Century Tire

Tue, Mar 29, 2016 at 8:54 AM

I realized I never circled back on comments on the sidewalk plan for Kennebec. I did get comments from Bruce Hyman. These are below.

Drawing file: 1_22_16 concepts / Trail Option B Detail - Revised Curb Line at Brattle.pdf

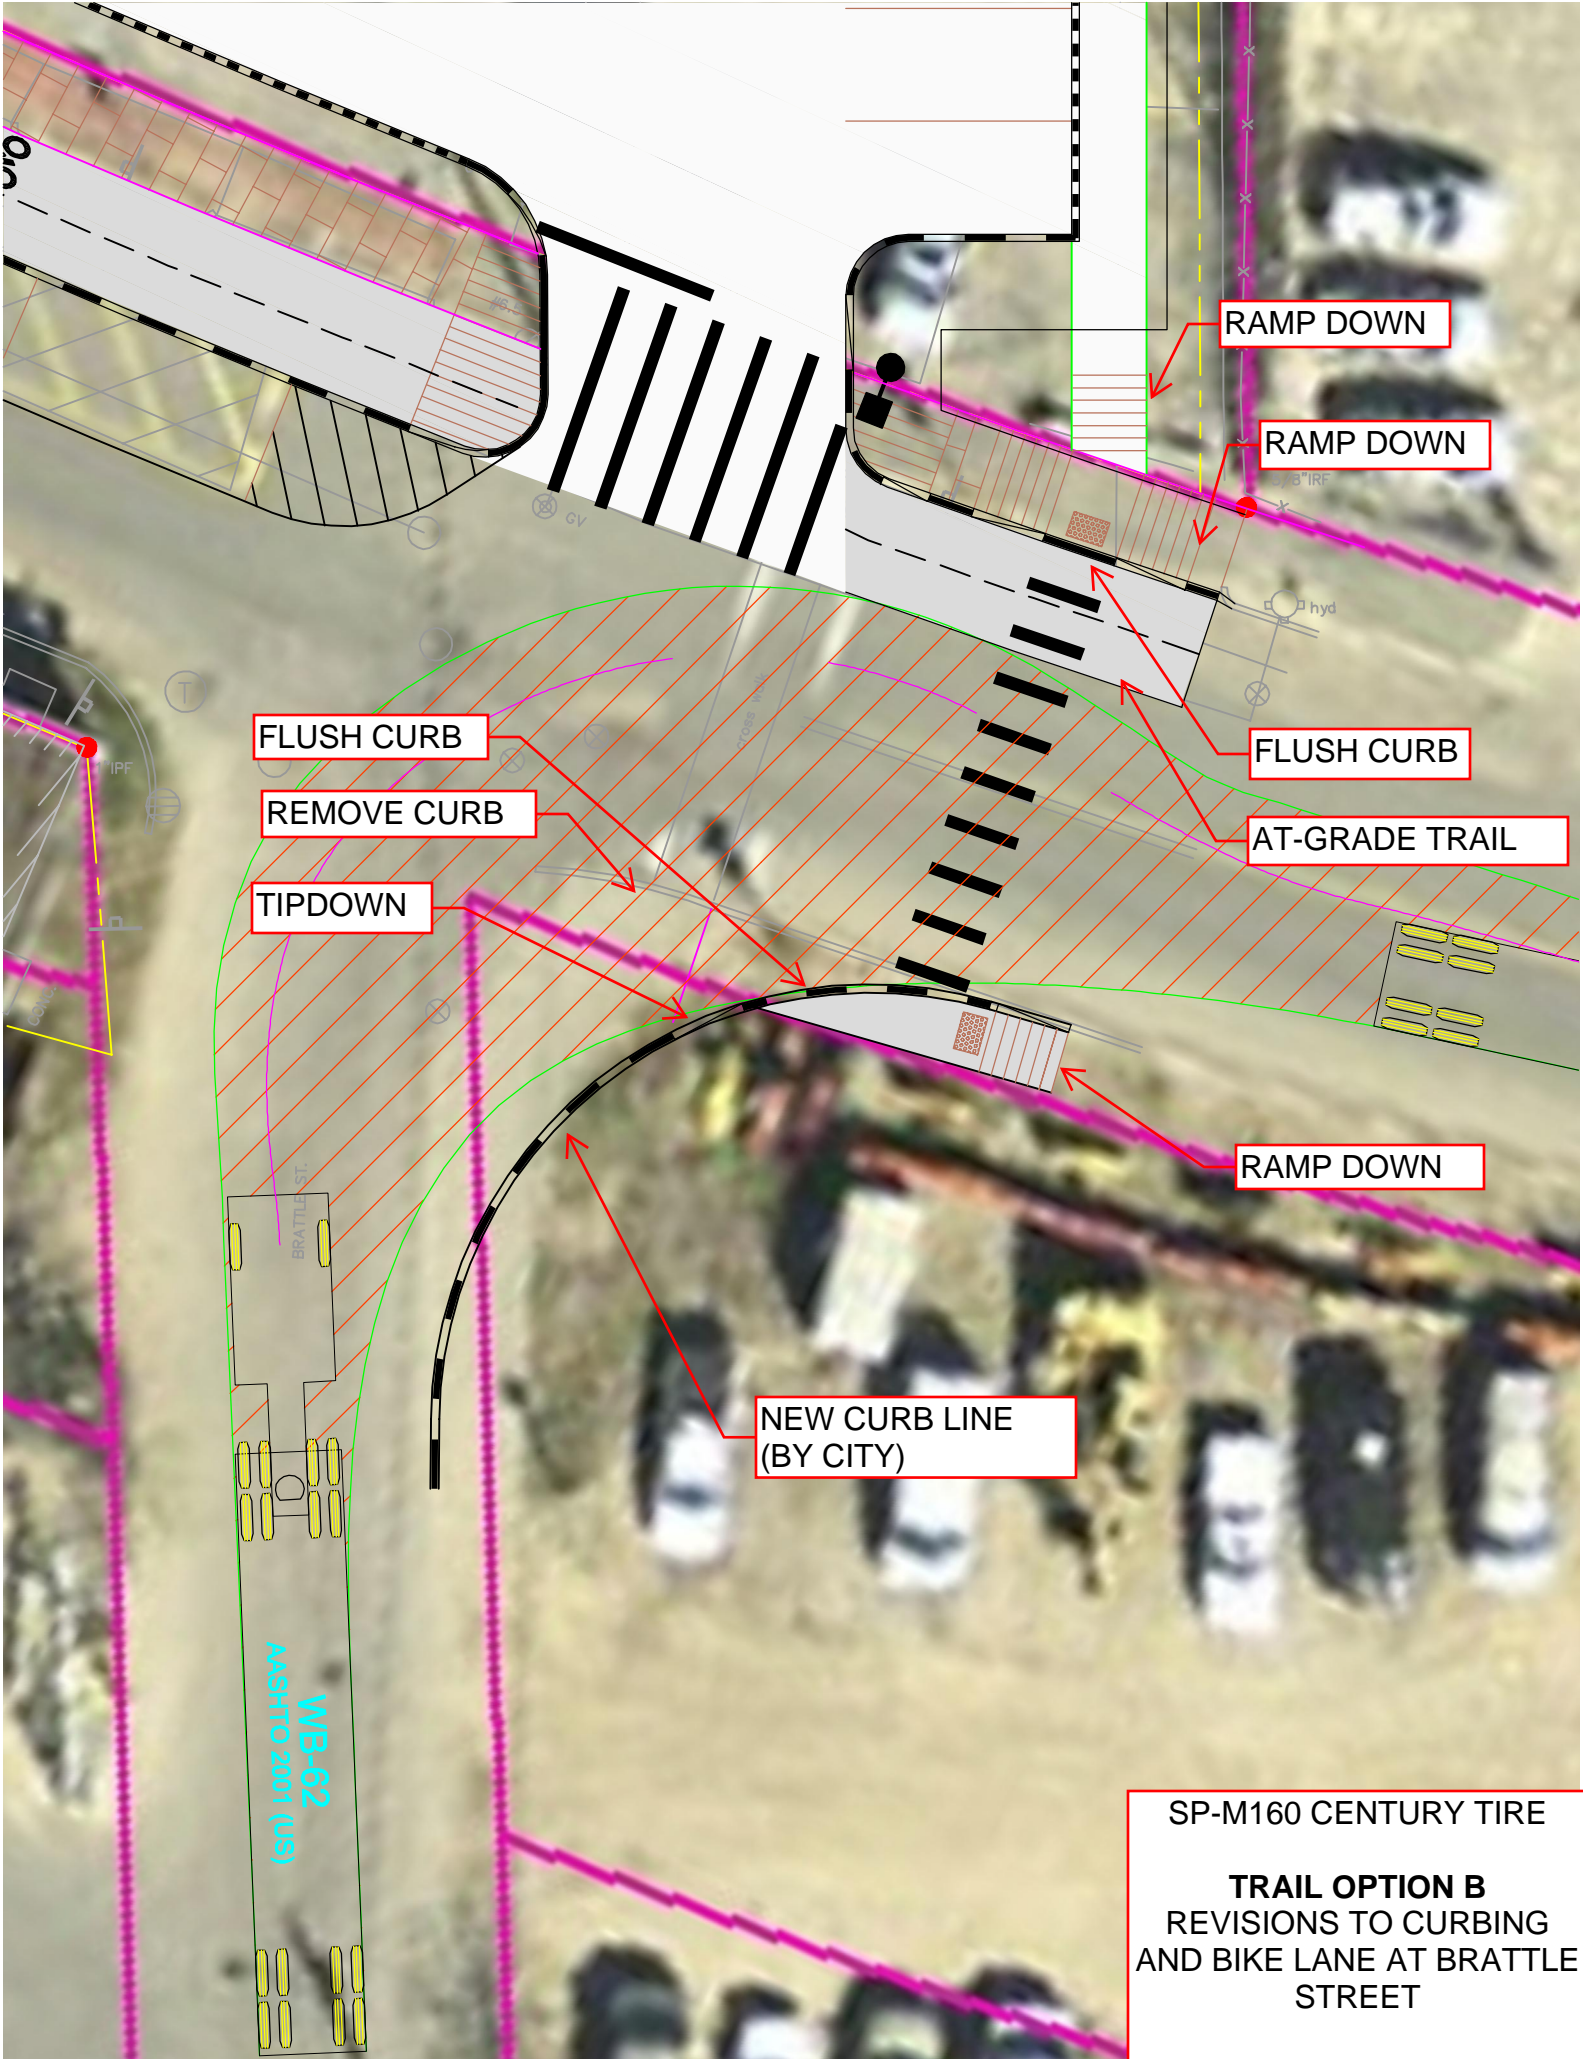
The only other comment is that I believe the crosswalk marking on Kennebec doesn't meet the Technical Manual spec. (See Figure I-22, or even the approved site plan, for the preferred design).

Other than the detectable warning panel needs to be shown (and built) to extend the full width of the ramp on the north side of the crosswalk at Brattle(? - the project side), it seems acceptable. If the curb ramp is 6' wide, the panel needs to be ~6' wide, etc, per ADA.
